Appeal Decision

Appeal Ref: APP/R5510/D/25/3366324

5 Crowland Avenue, Hillingdon, Hayes UB3 4JN

- The appeal is made under section 78 of the Town and Country Planning Act 1990 (as amended) against a refusal to grant planning permission.
- The appeal is made by Mr Surinder Singh against the decision of the Council of the London Borough of Hillingdon.
- The application Ref is 48814/APP/2025/525.
- The development proposed is described as an "Erection of a single storey rear extension, and a first floor rear extension."

Proposed Floor Plans

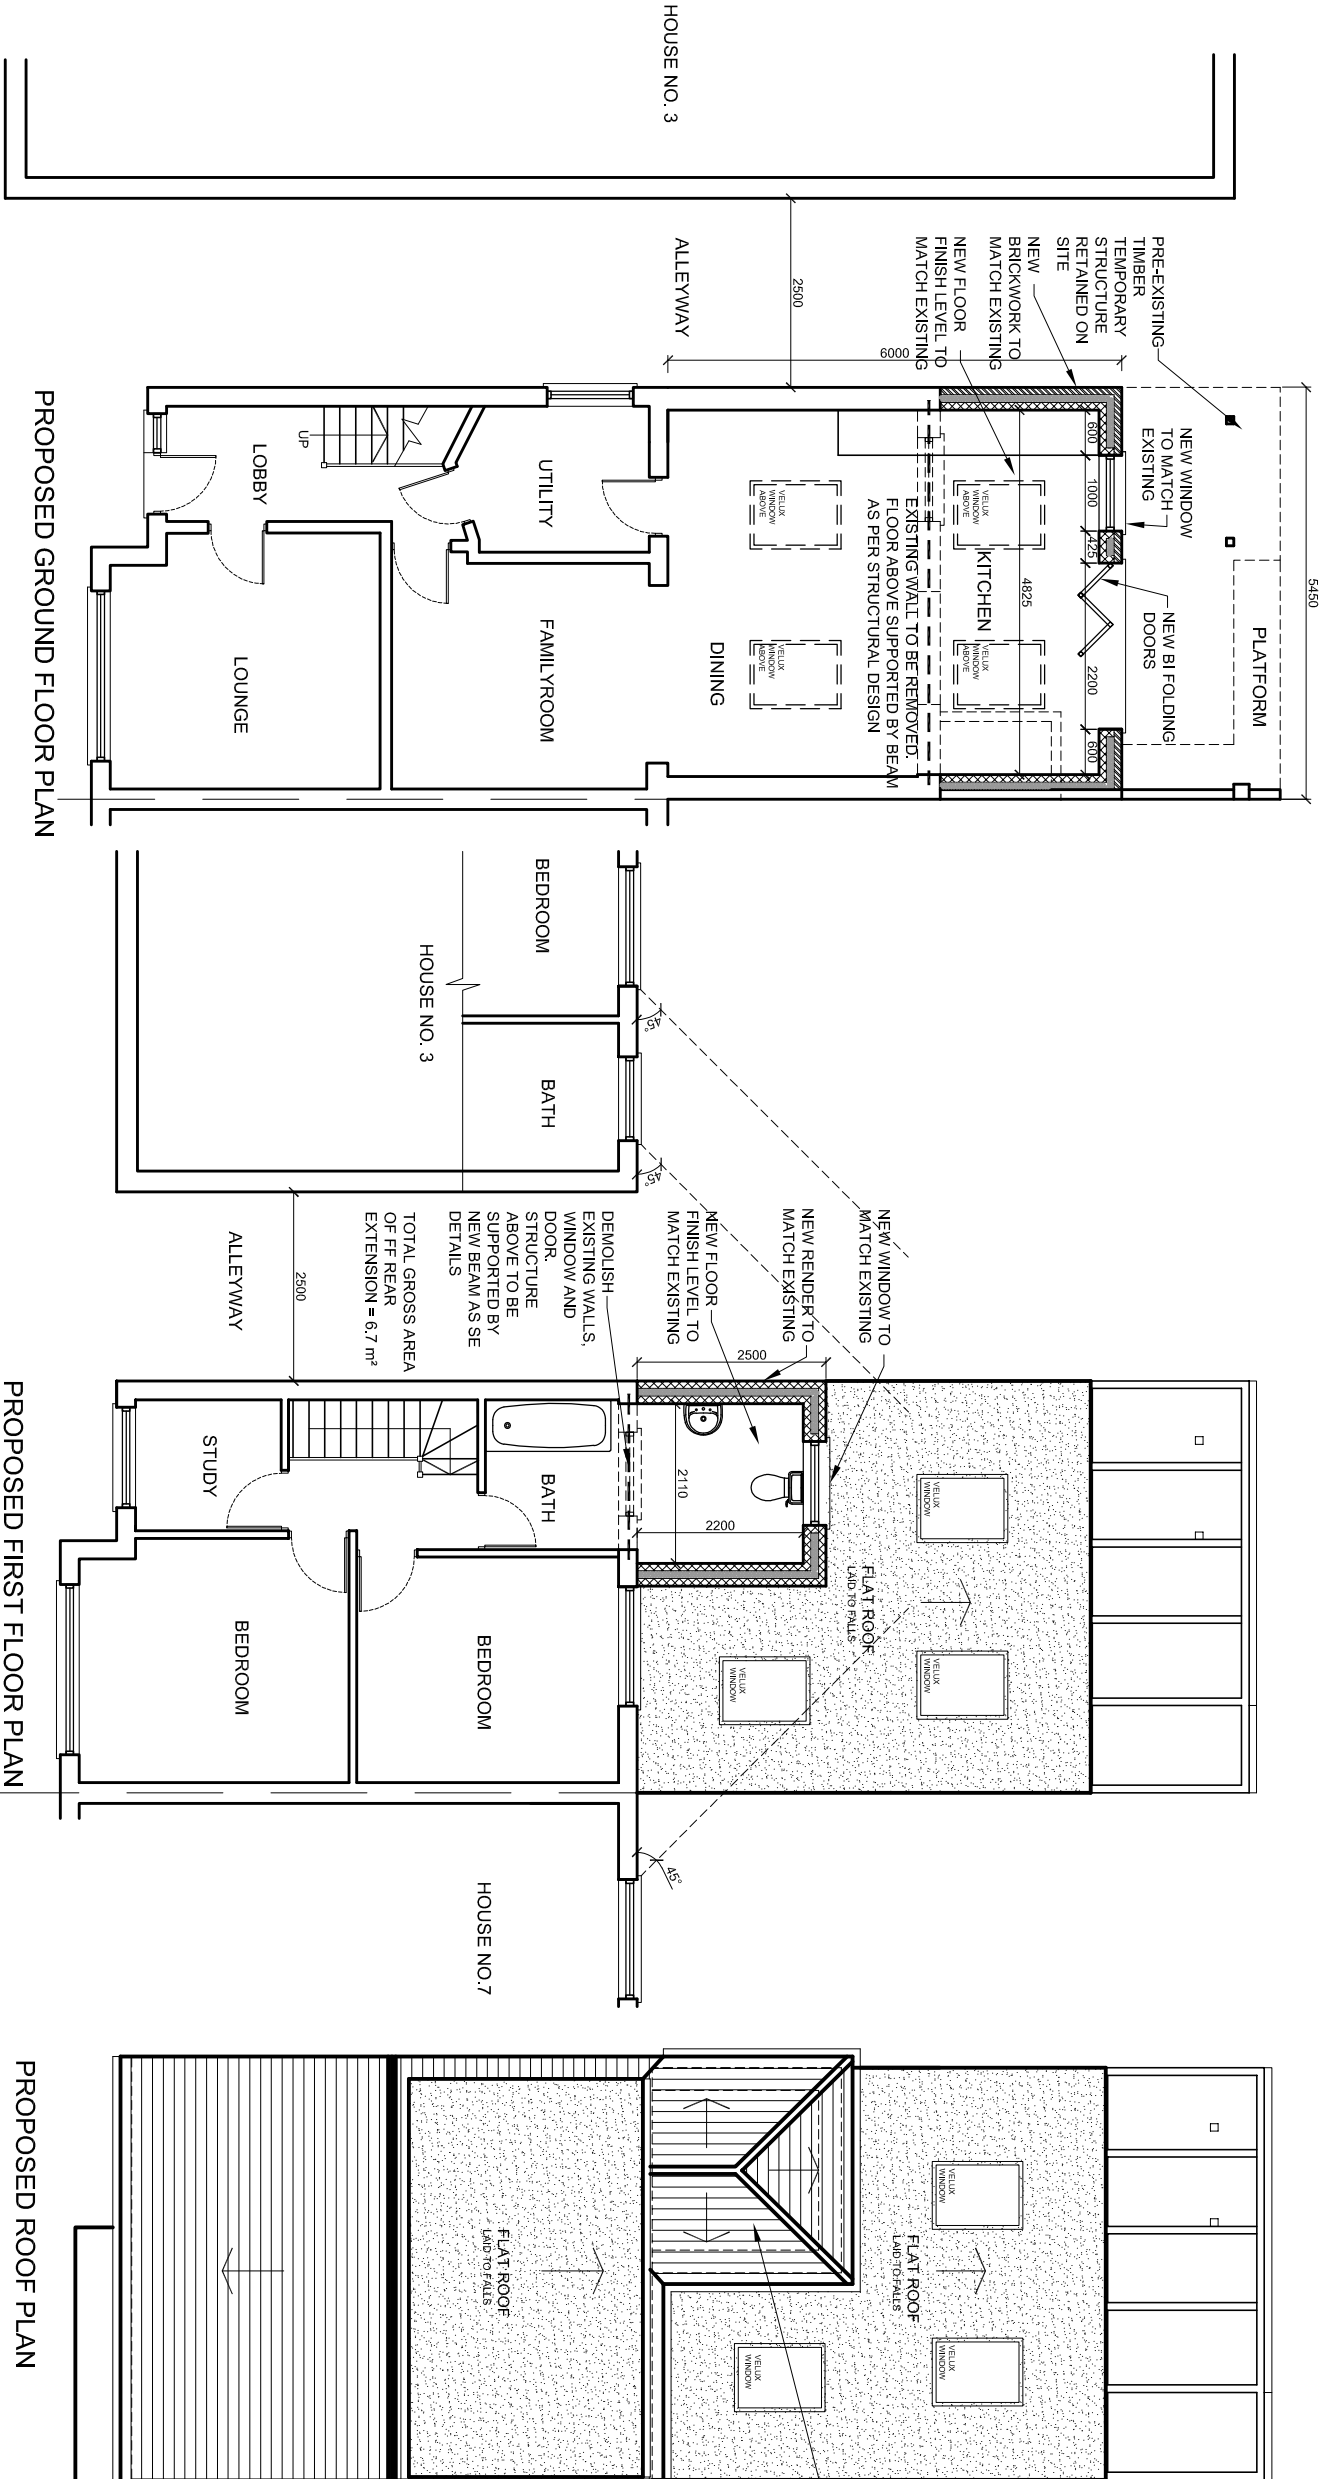
7. When viewed cumulatively with the existing alterations at no 5, the proposed extensions would fail to appear subservient to the original dwelling. Instead, they would result in a visually dominant form that would undermine the character and appearance of both the host property and pair of semi-detached properties it forms part of, as well as the wider area. While the single-storey rear extension has been approved under a previous application and may be acceptable in isolation, its combination with the proposed first-floor addition and the existing rear dormer would create excessive bulk, scale, and massing relative to that of the existing building. The resulting built form would span three storeys, an extent of development not mirrored in neighbouring properties. Moreover, the proposal would further project beyond the existing ground-floor extension, exceeding the depth of any comparable extension visible in the immediate vicinity.

8. While I acknowledge the inclusion of various design features, such as the matching roof form, materials, and positioning, and accept that the proposal may meet certain individual design criteria, these elements do not sufficiently mitigate the overall harm arising from the cumulative scale of development. Nor would the removal of the existing rear canopy structure meaningfully reduce this impact. Taken as a whole, the scheme would result in a visually dominant and incongruous addition that fails to respect the established character and appearance of both the host property and the wider area. Although the proposed extensions would not be widely prominent within the street scene, they would nevertheless be partially visible due to the gap between the appeal site and no 3. Furthermore, the harm caused by the proposal would be clearly apparent from neighbouring properties.

12. Given the above, the proposed development would cumulatively cause unacceptable harm to the character and appearance of the host property and the wider area. Consequently, it would conflict with Policy BE1 of the Hillingdon Local Plan: Part One – Strategic Policies (Adopted 2012) and Policies DMHD1, DMHB11 and DMHB12 of the Hillingdon Local Plan: Part Two – Development Management Policies (Adopted 2020). Amongst other things, these policies require development to ensure there is no adverse cumulative impact of the proposal on the character, appearance or quality of the existing street or wider area, be subordinate and respect the design of the original house, and harmonise with the local context by taking into account the surrounding scale of development.
